M25 junction 10/A3 Wisley interchange TR010030 8.4 Statement of Common Ground with Historic England

8.4 STATEMENT OF COMMON GROUND WITH HISTORIC ENGLAND

STATEMENT OF COMMON GROUND

This Statement of Common Ground has been prepared and agreed by (1) Highways England Company Limited and (2) the Historic Buildings and Monuments Commission for England (Historic England).

Drawing Title: **WISLEY LANE EMBANKMENT CONSTRUCTION PHASE 2 REGULATION 5(2)(o) SHEET 2 OF 4**

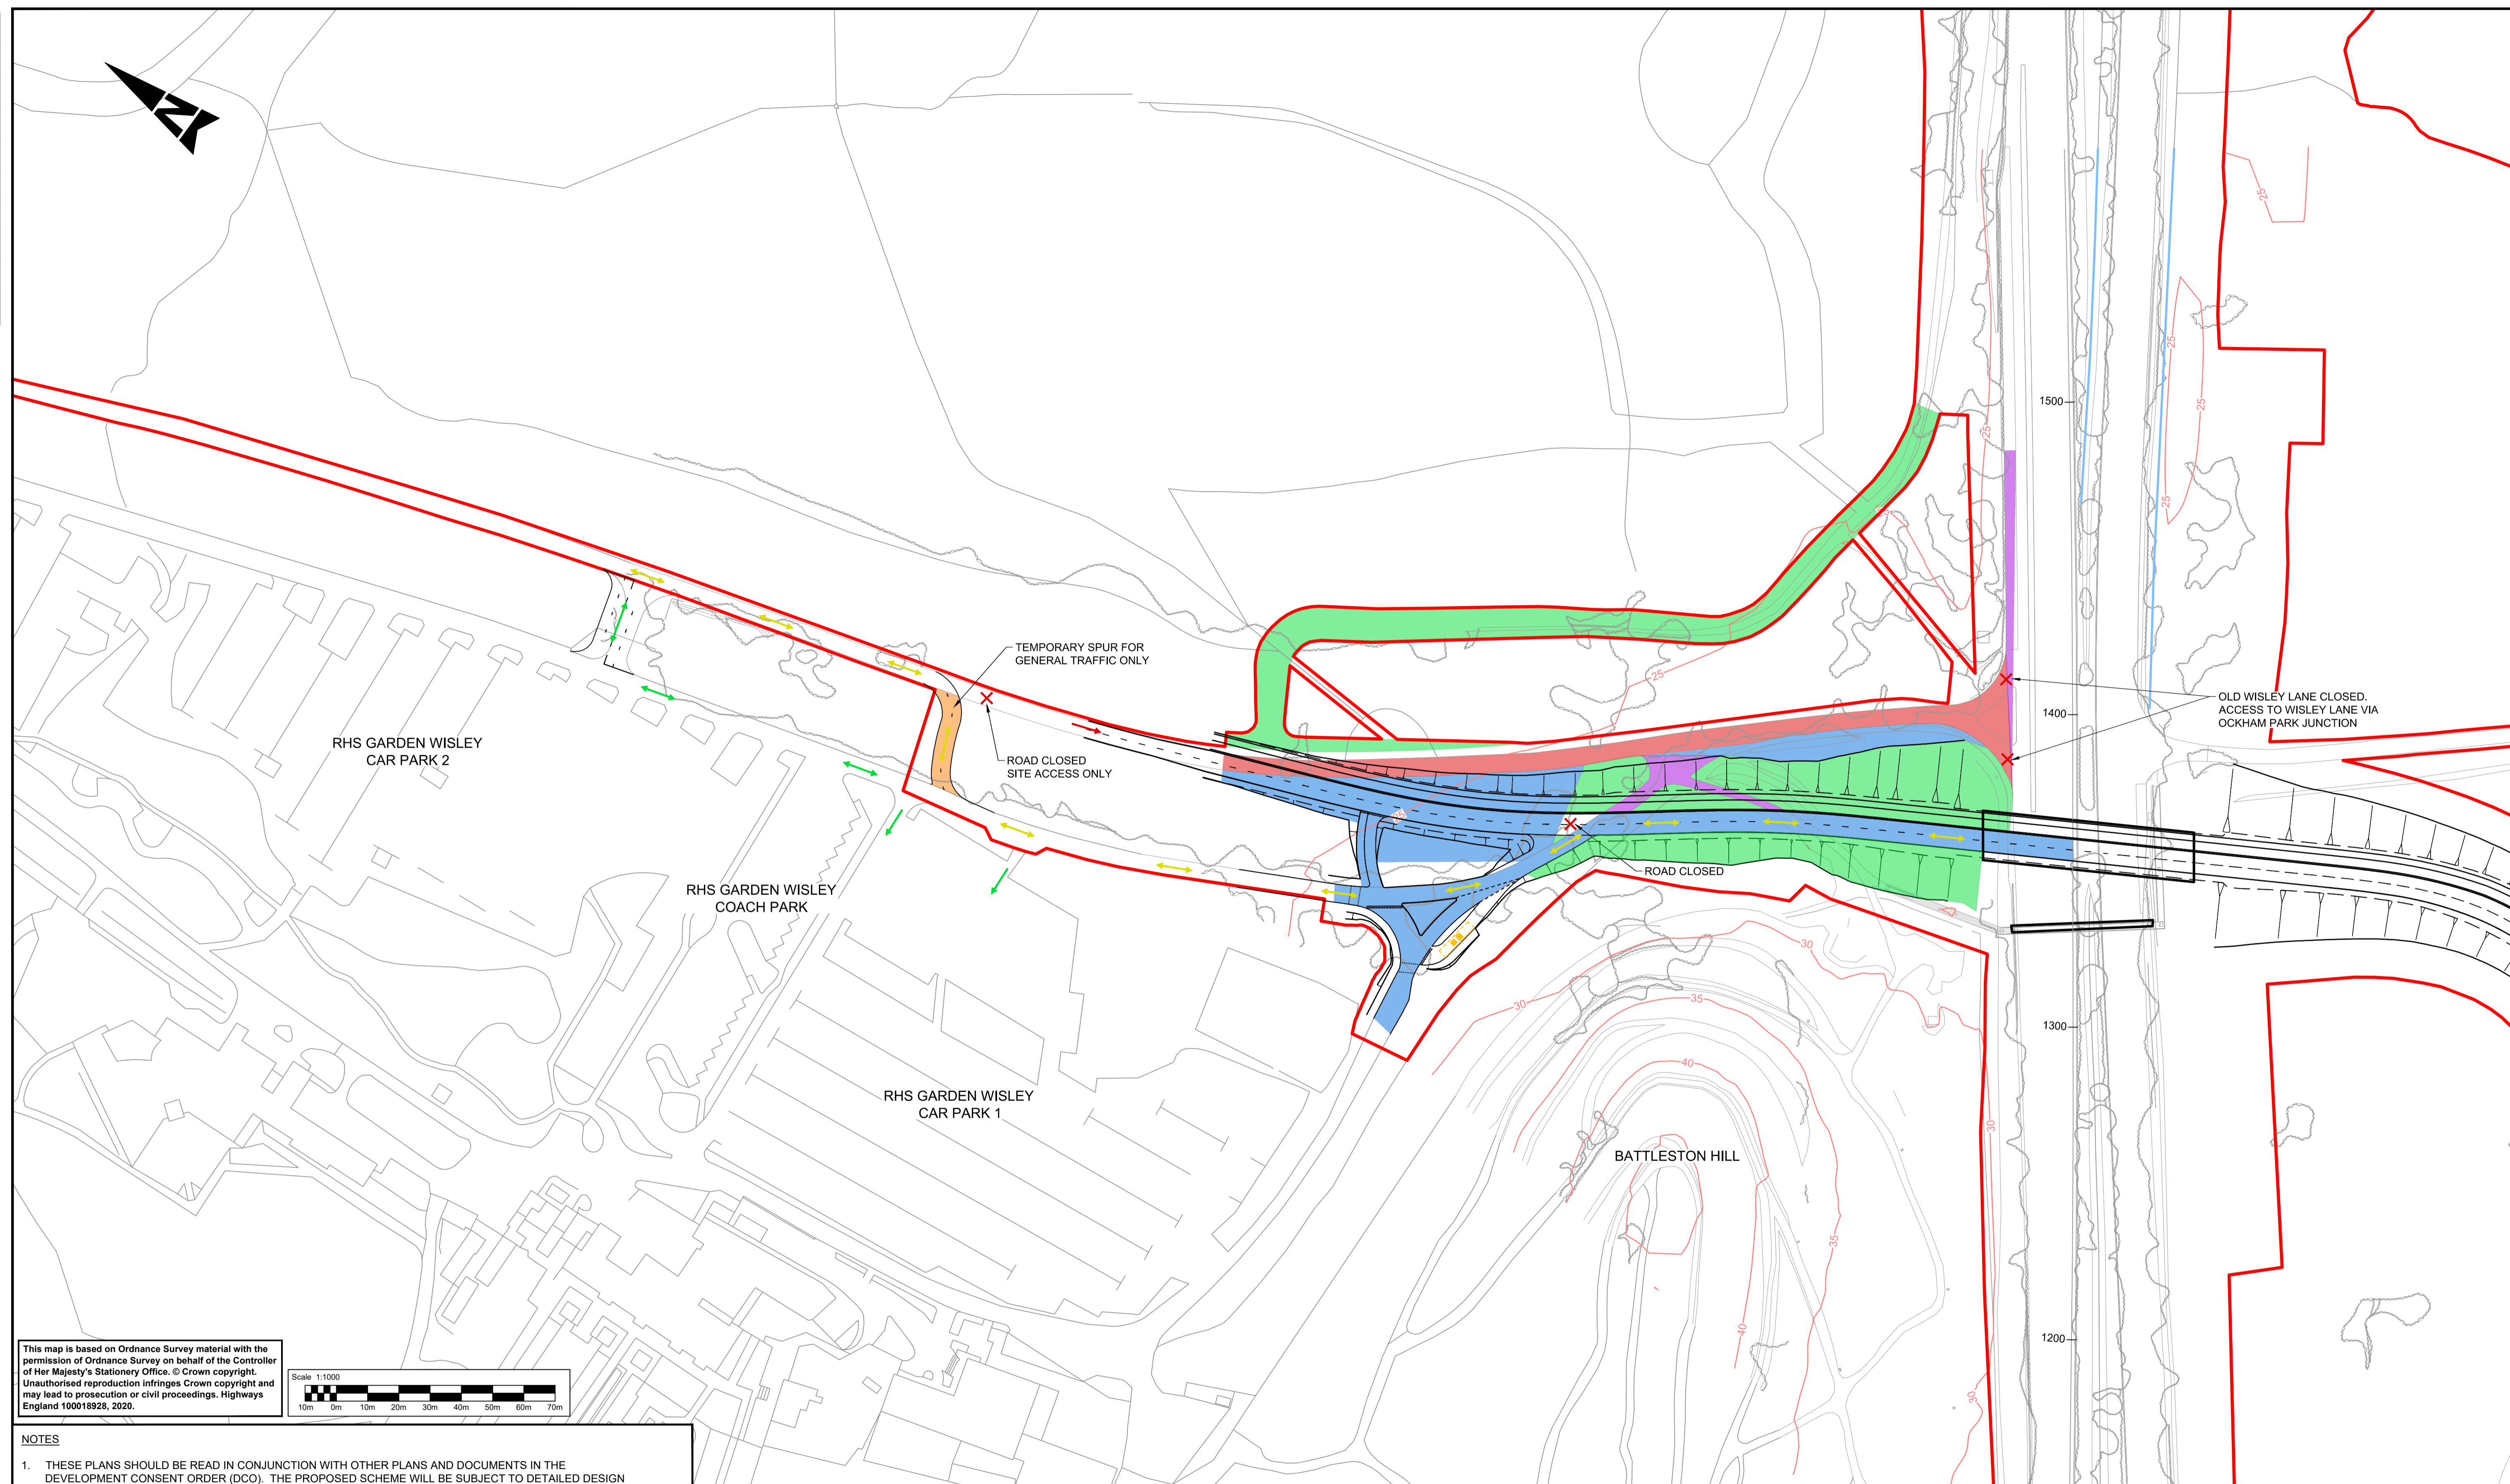
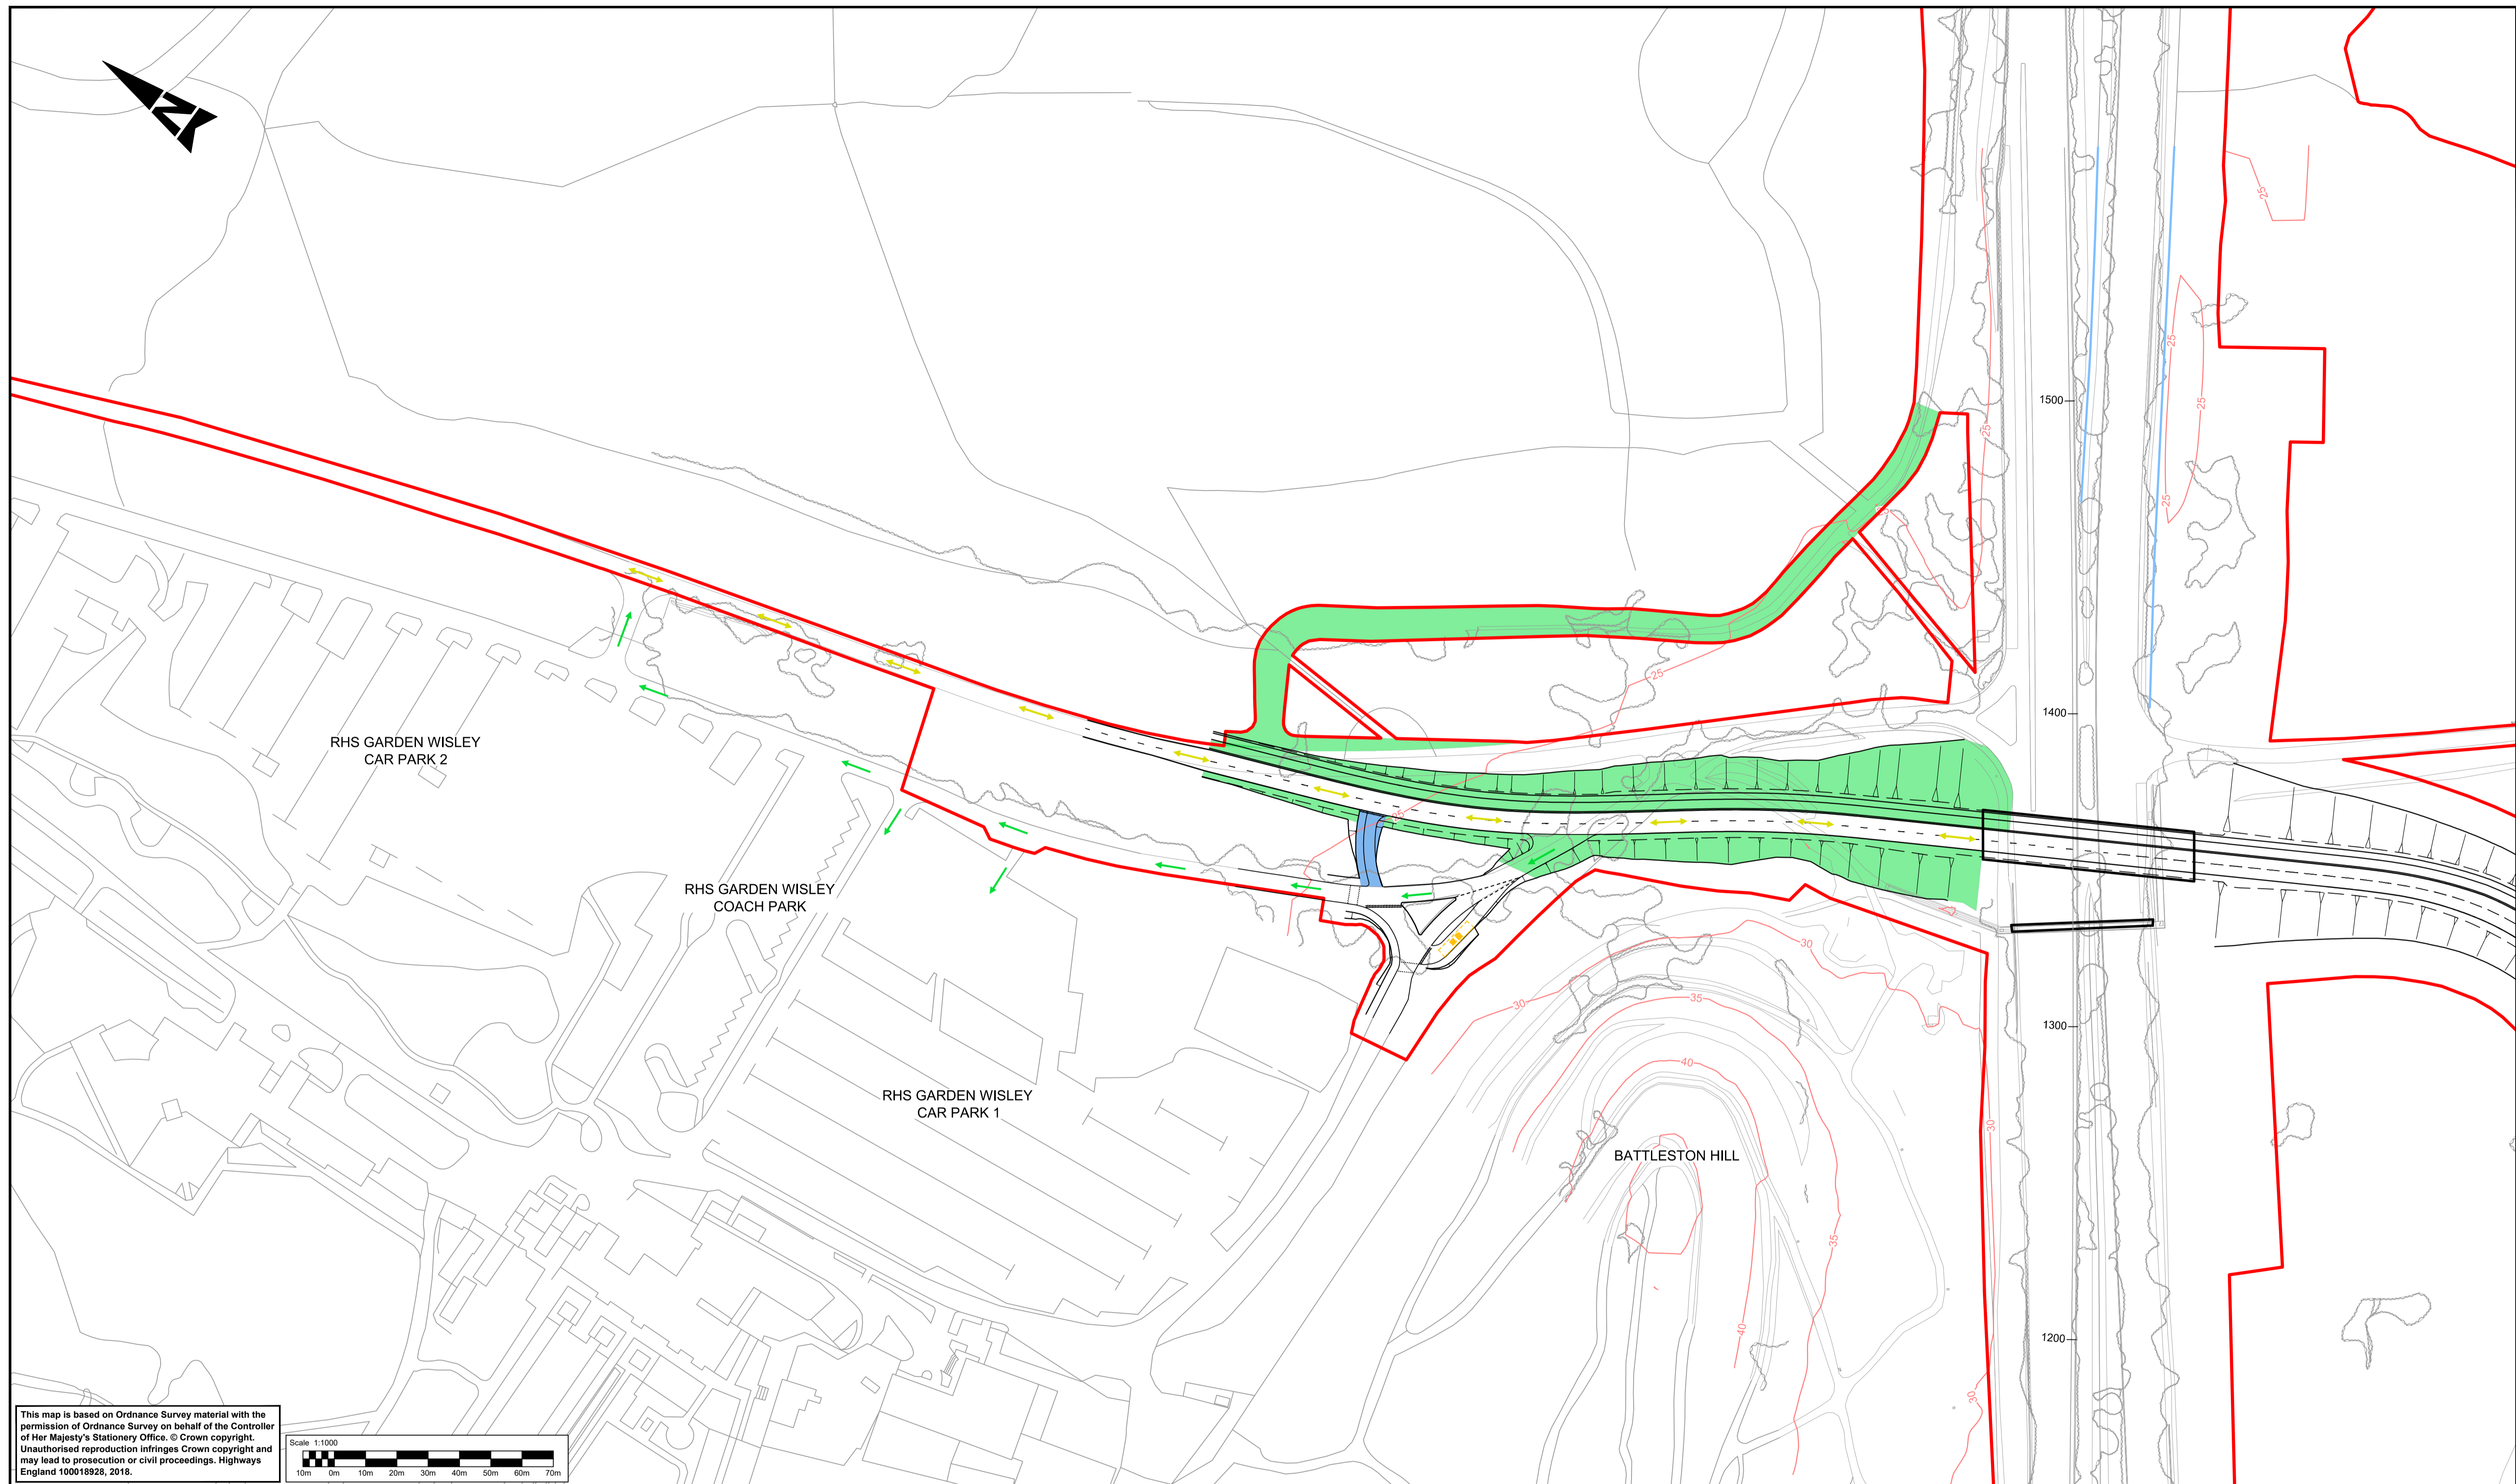
3.2.12	RHS Wisley	RHS Wisley; Scheme design	More detail is required on the design of construction within RHS Wisley at the north-east corner where the existing footbridge will be rebuilt as a road bridge. Historic England wants to consider this before agreeing what the effect on the significance of the heritage asset will be.	The Scheme design near RHS Wisley has been modified to address concerns raised by RHS Wisley and Historic England. In pre-Environmental Statement meetings.	Agreed
